Ribble Valley Borough Council
Housing & Development Control

Your ref: 3/2024/0096
Our ref: D3.2024.0096
Date: 20th May 2024

Application no: **3/2024/0096**

Proposal: **Proposed replacement boundary fencing using 2.0m/2.4m high welded mesh fencing. Creation of new vehicular access from Little Lane, two pedestrian gates from Preston Road (non-automated), one automated vehicle and pedestrian gate from Preston Road and one automated pedestrian gate from existing barrier car park area.**

DRAWING TITLE:
Site Plan with Proposed Fencing

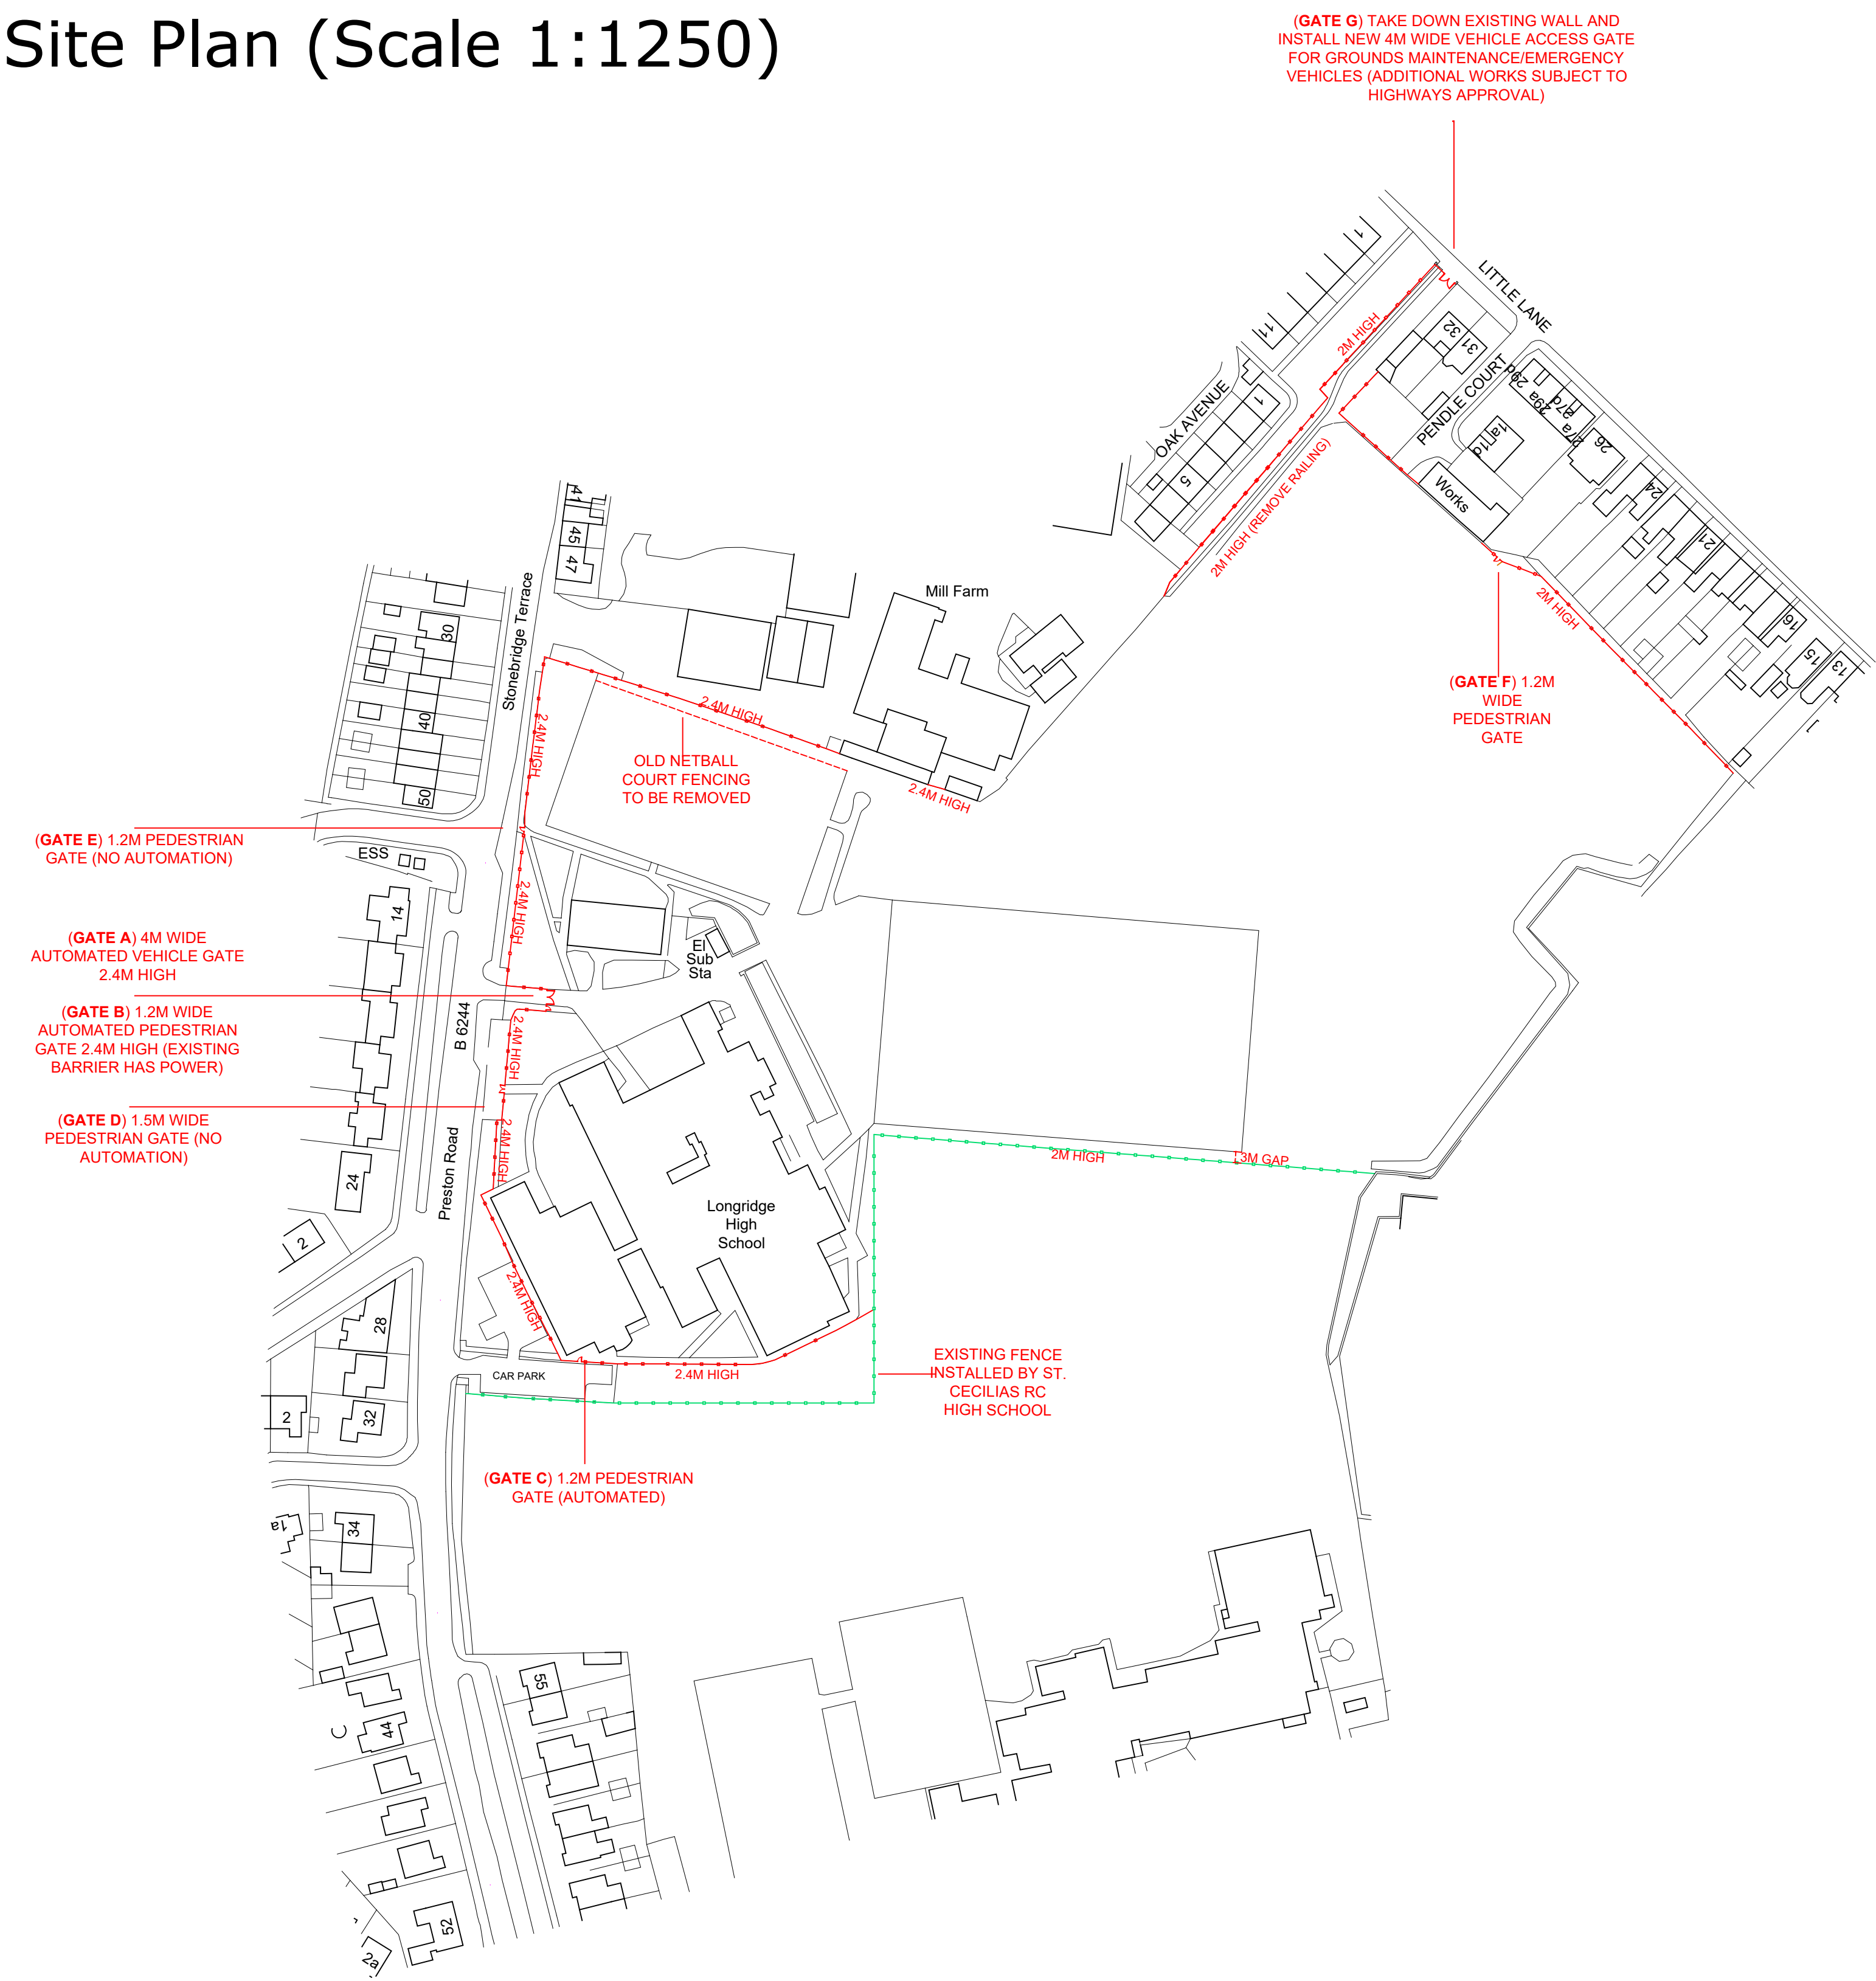
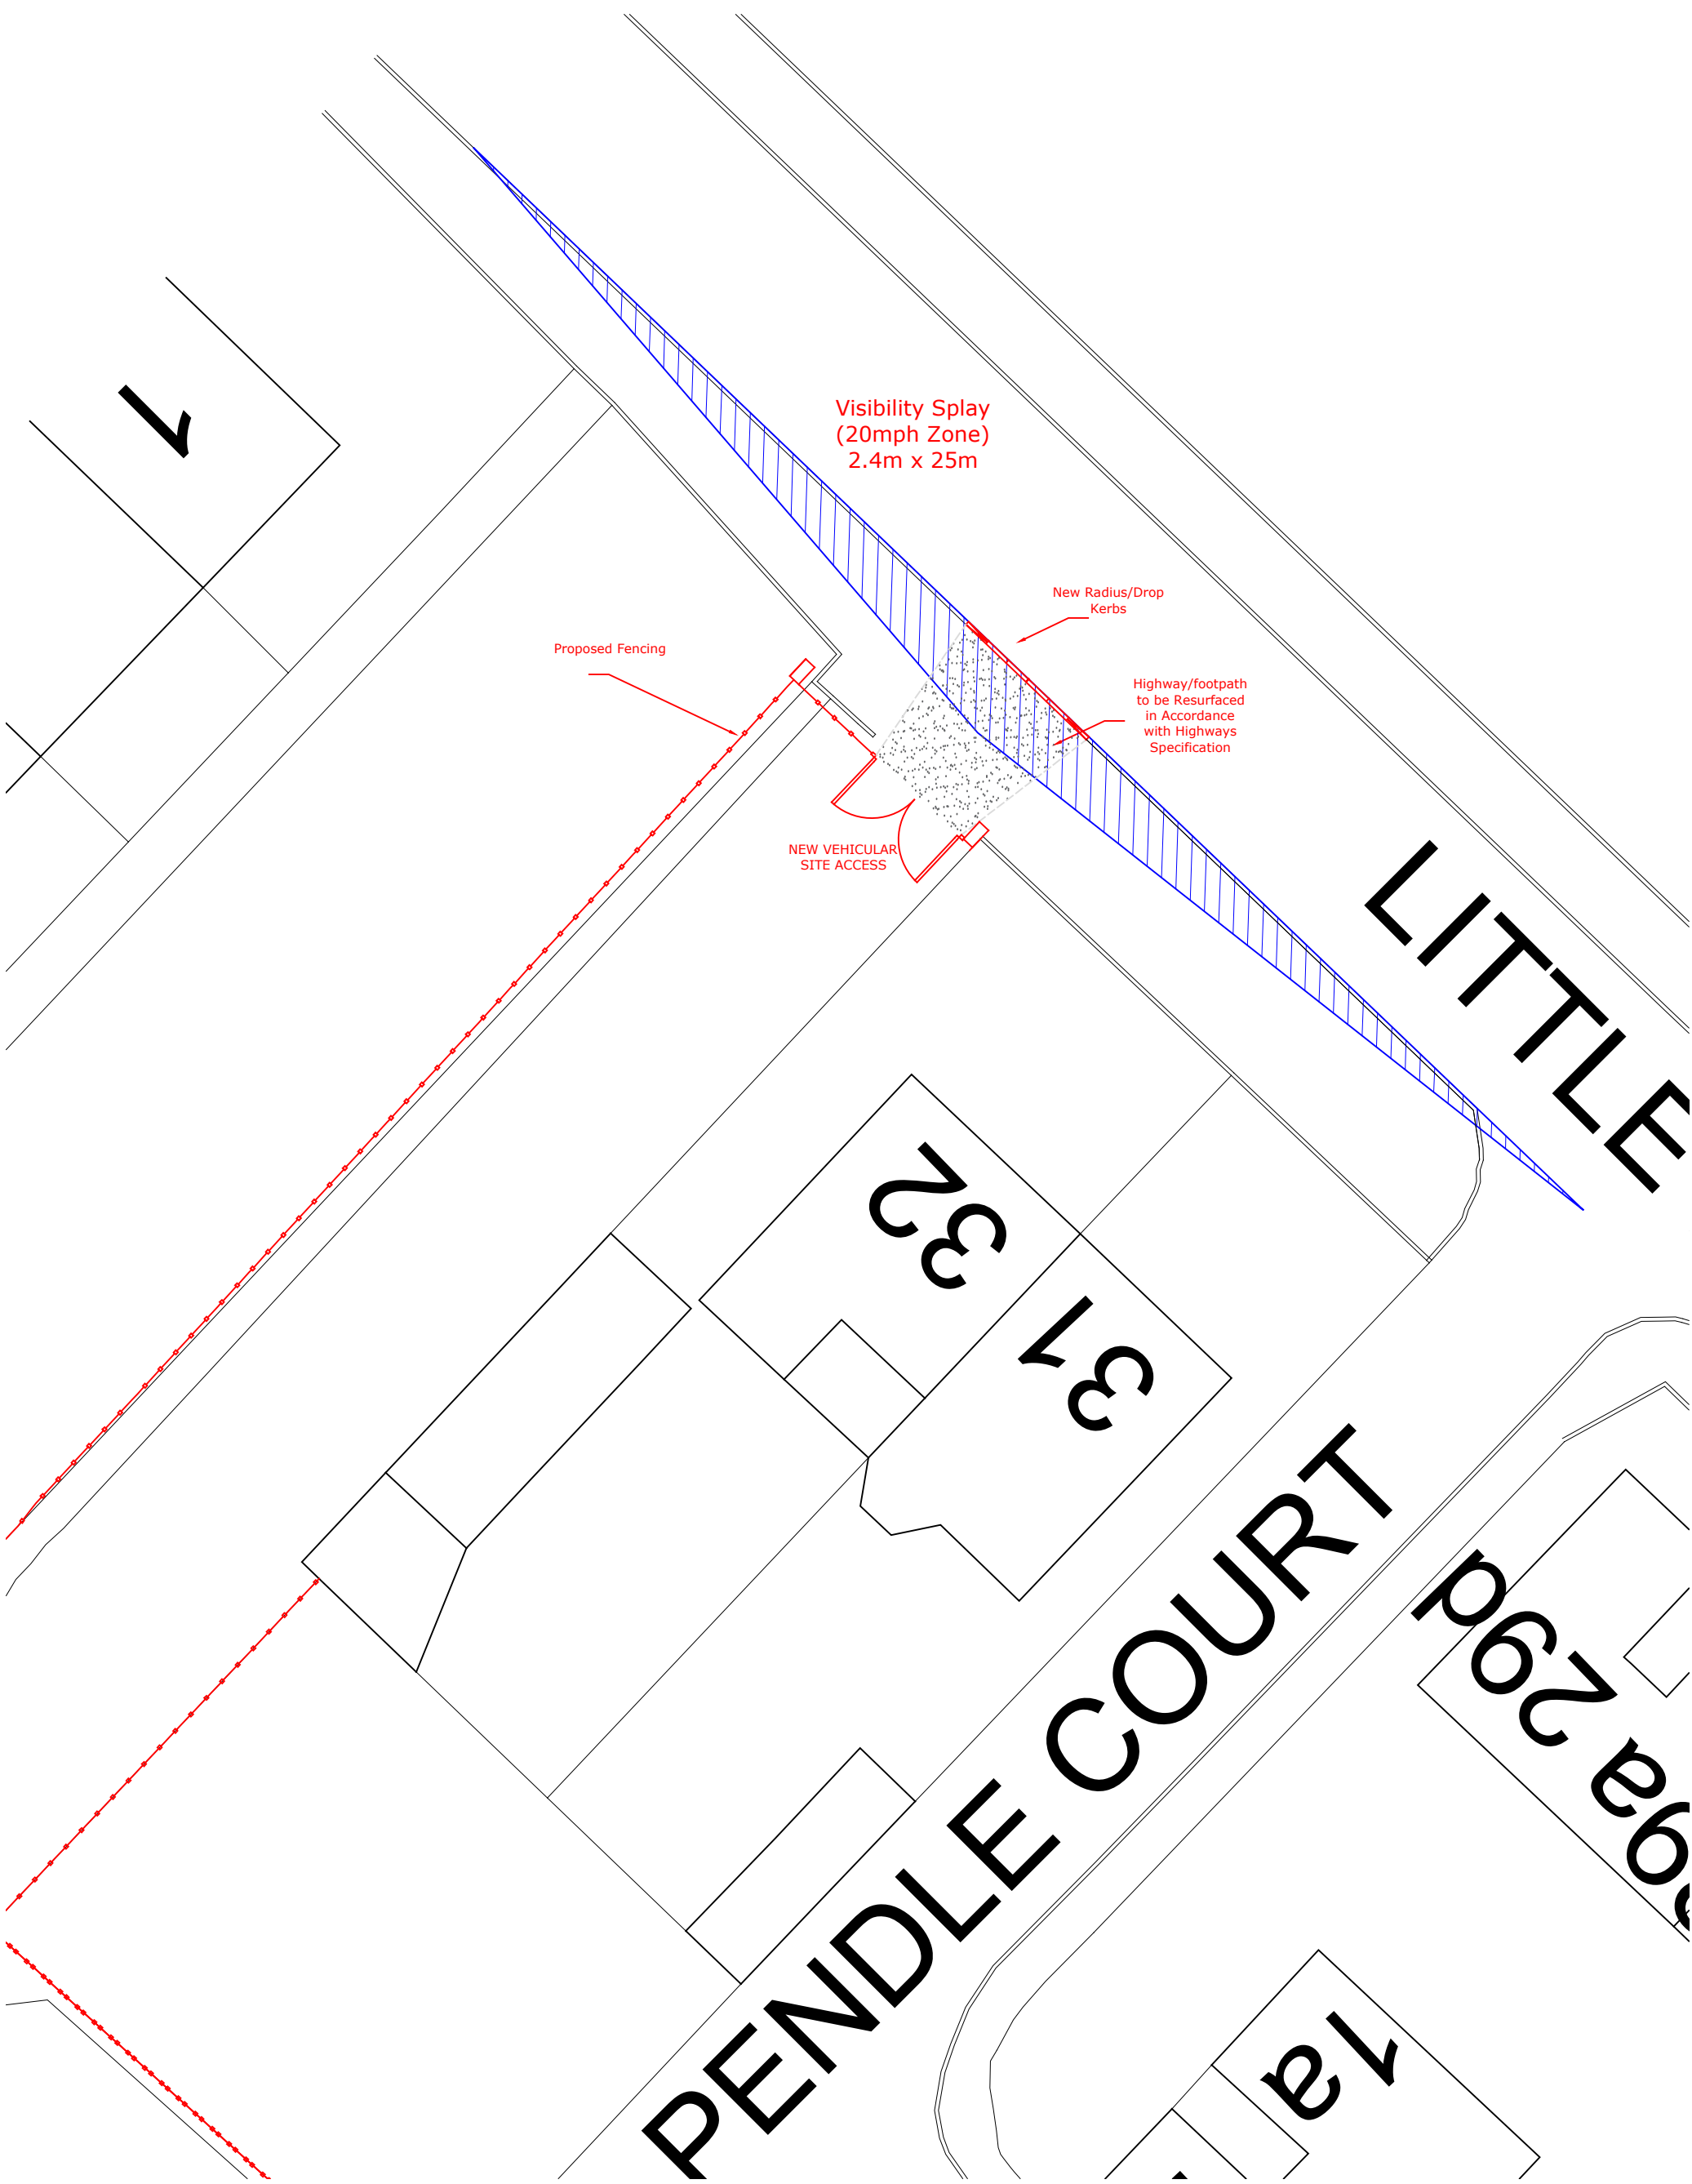
The reviewed Lea Hough drawing number BS-23-277-02 Rev B titled "Site Plan with Proposed Fencing" and have no objection to the proposed replacement boundary fencing around the perimeter of the school. The LHA also have no objection to the replacement or provision of gates to the pedestrian or vehicular accesses which front Preston Road.
